August 2, 2024

RE: 14982 Longwall Court
Colorado Springs, CO 80908

14982 LONGWALL COURT

14982 LONGWALL COURT

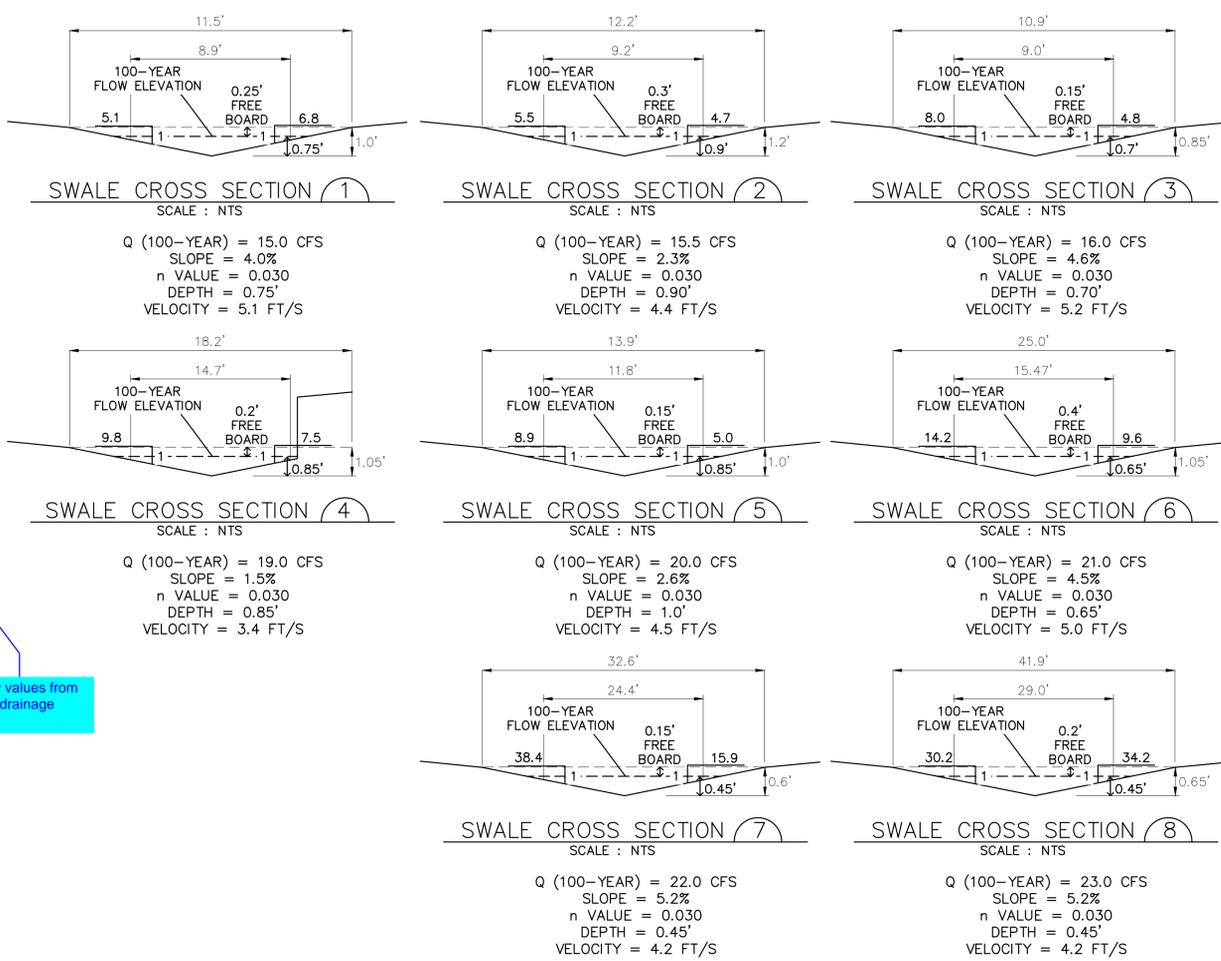
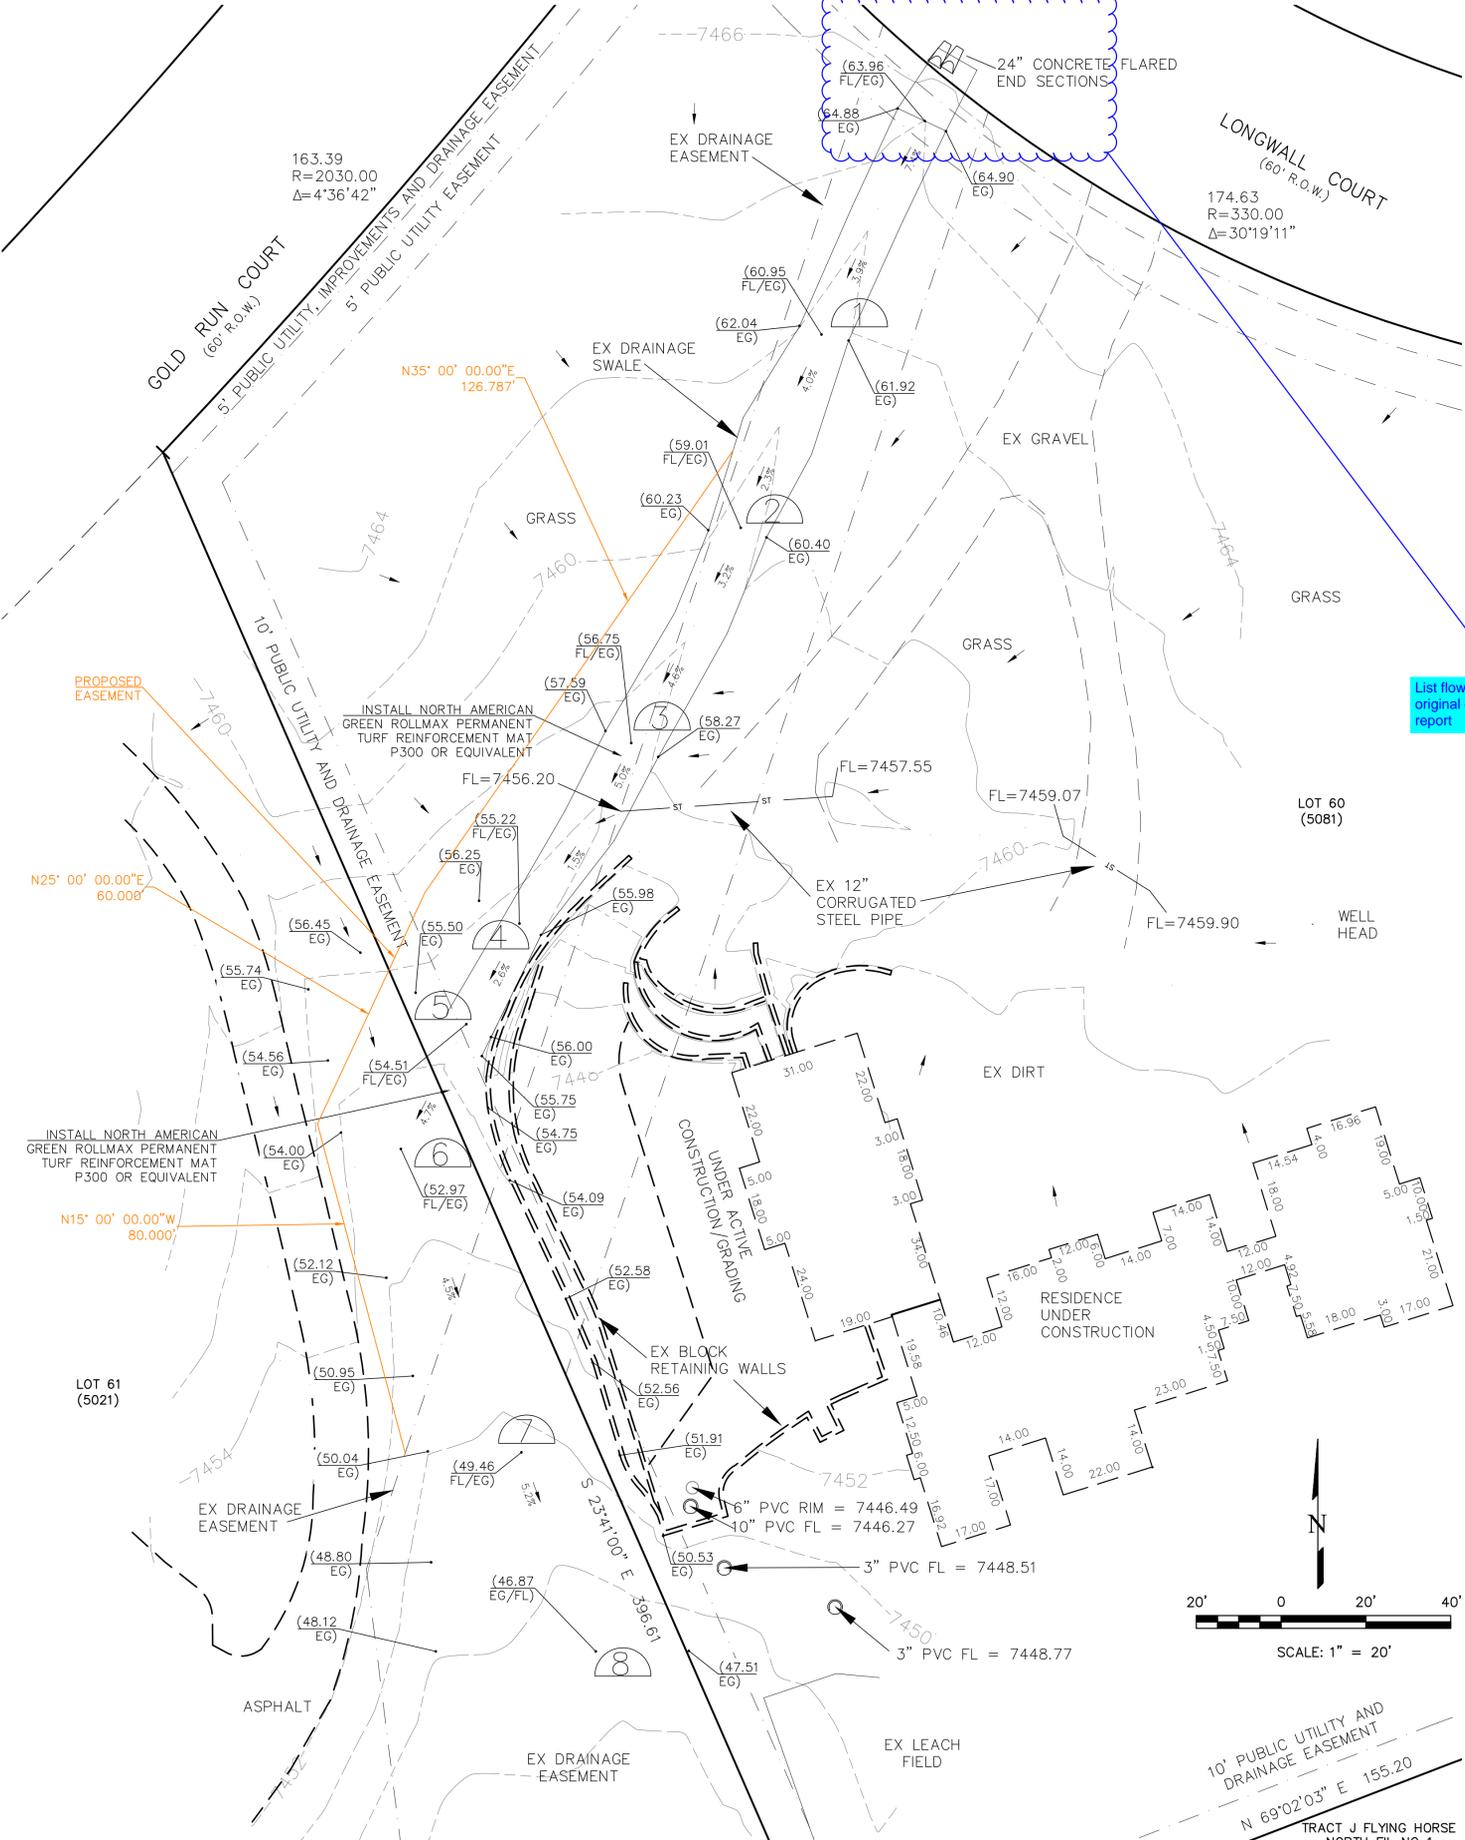
Please add standard signature blocs to letter
Please add original drainage report excerpt (attach to letter) and list flows on the grading and drainage plan
